# SITE DEVELOPMENT PLAN FOR WALDEN SANITATION DISTRICT WASTEWATER TREATMENT PLANT PROJECT EL PASO COUNTY, COLORADO MARCH 2026

# V3\_ Site Dev Plan.pdf Markup Summary

PROJECT: WALDEN CORPORATION WWTP 3155 WALKER ROAD COLORADO SPRINGS EL PASO COUNTY, COLORADO		SHEET TITLE: SITE DEVELOPMENT PLAN	
ENGINEER: AQUAWORKS DBO, INC. 3252 WILLIAMS STREET DENVER, COLORADO 80205 (303) 477-5915	PROJECT NUMBER: PCD FILE PPR2538	SCALE: 1" = 80'	SHEET: C1.2

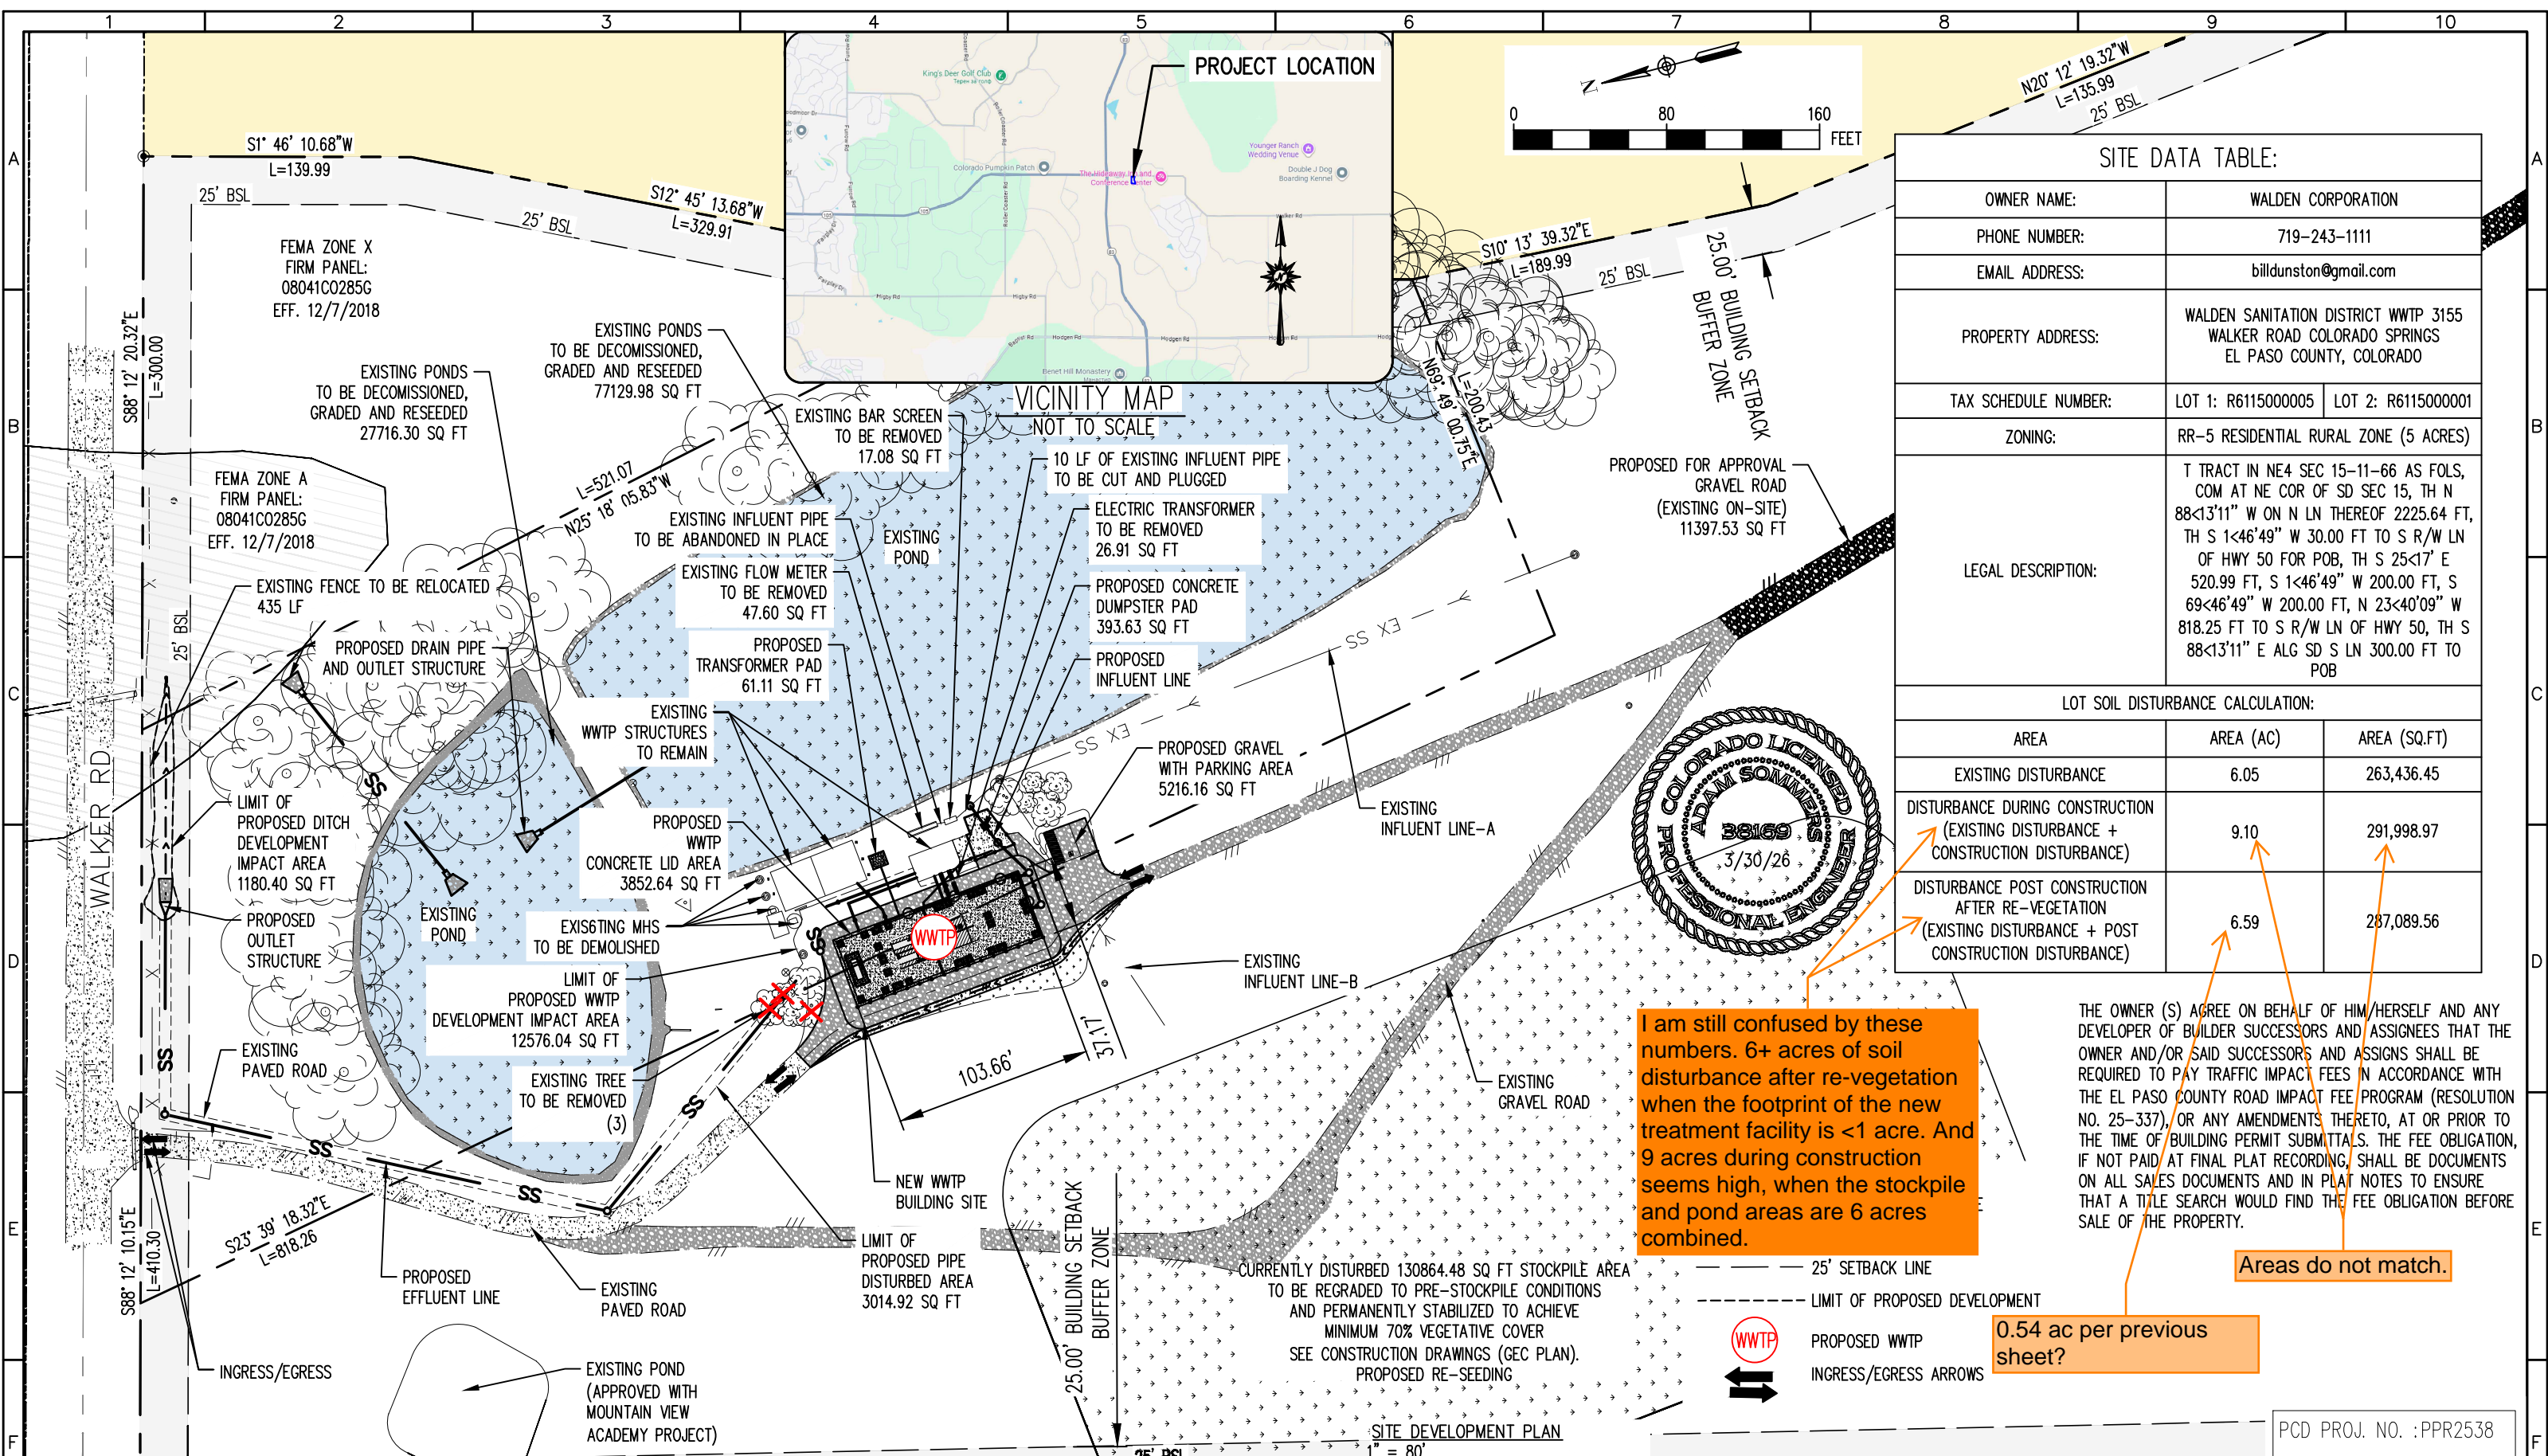
I am still confused by these numbers. 6+ acres of soil disturbance after re-vegetation when the footprint of the new treatment facility is <1 acre. And 9 acres during construction seems high, when the stockpile and pond areas are 6 acres combined.

Areas do not match.

0.54 ac per previous sheet?

Updated as per request.

Now it's 0.75, I fixed the numbers and also added proposed for approval gravel road
